Re.: Planning Application No. M/88/21/PL - 155 Middleton Road

With reference to the above planning application for a Hot Food and Coffee Truck, I would like to object for the following reasons:-

SITE PLAN (1:100)

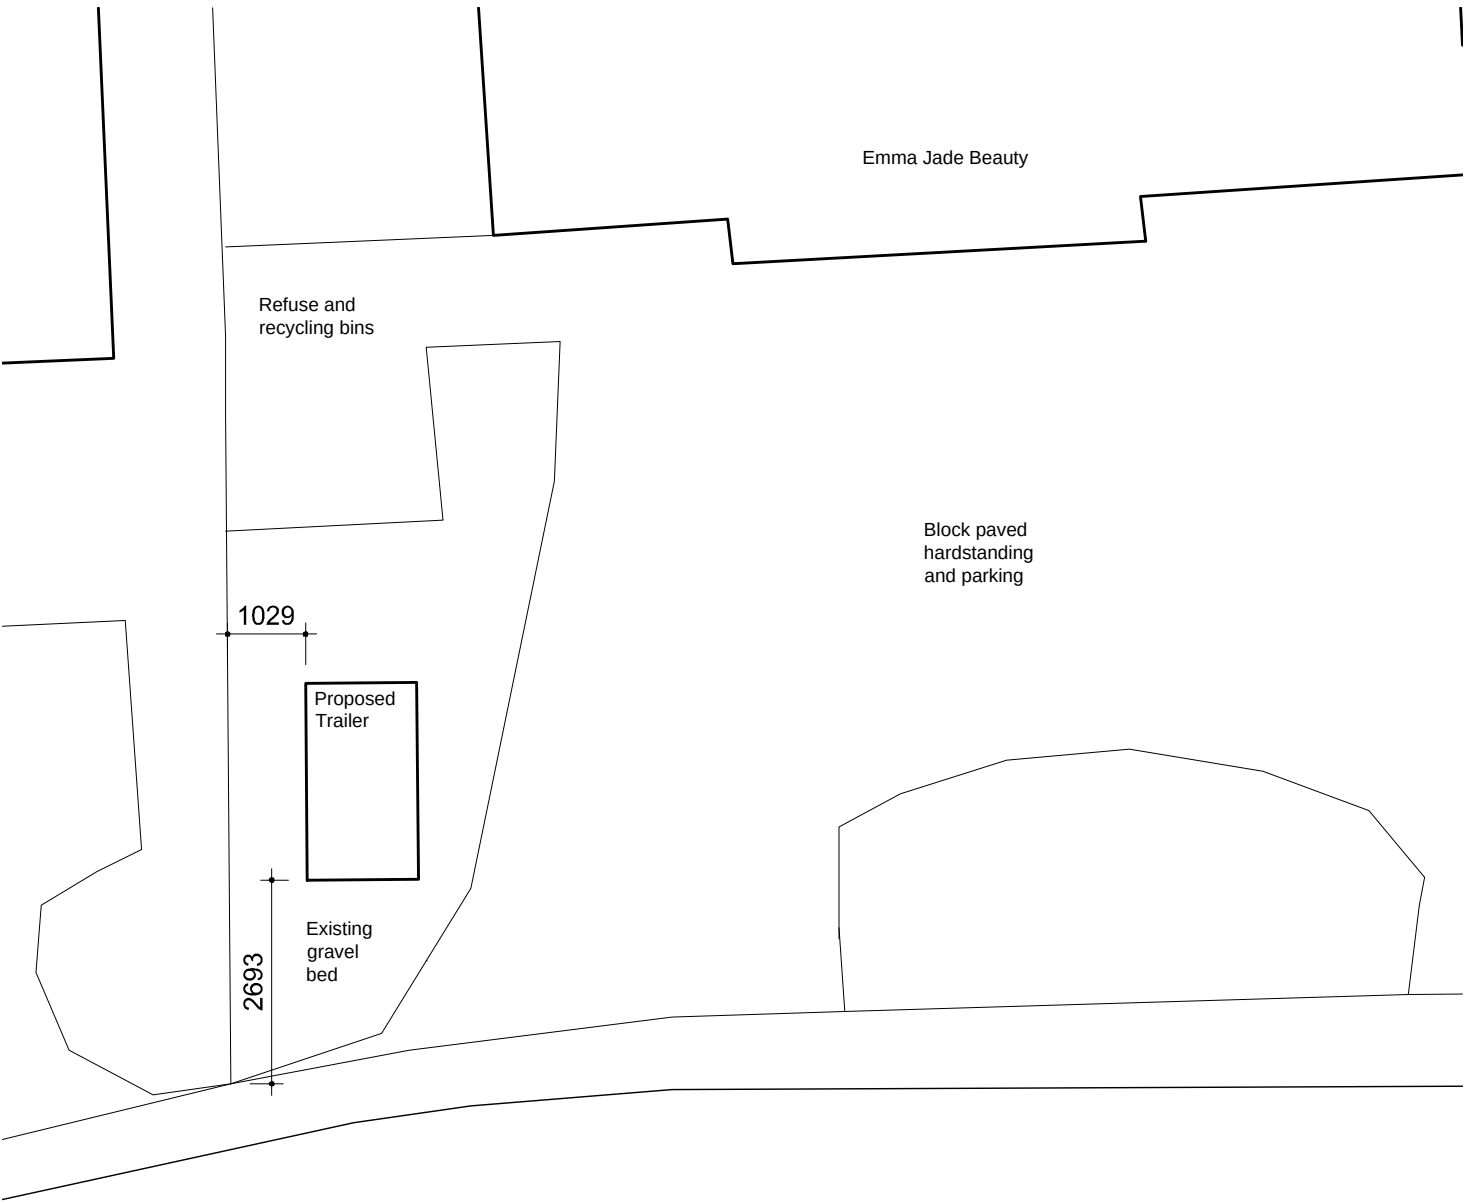
2. The truck/trailer which is going to be stationed there permanently, therefore quasi a permanent structure will be in front of the building line.
3. It will be right next to a residential block and only a few feet from the windows of the lower ground floor flat.
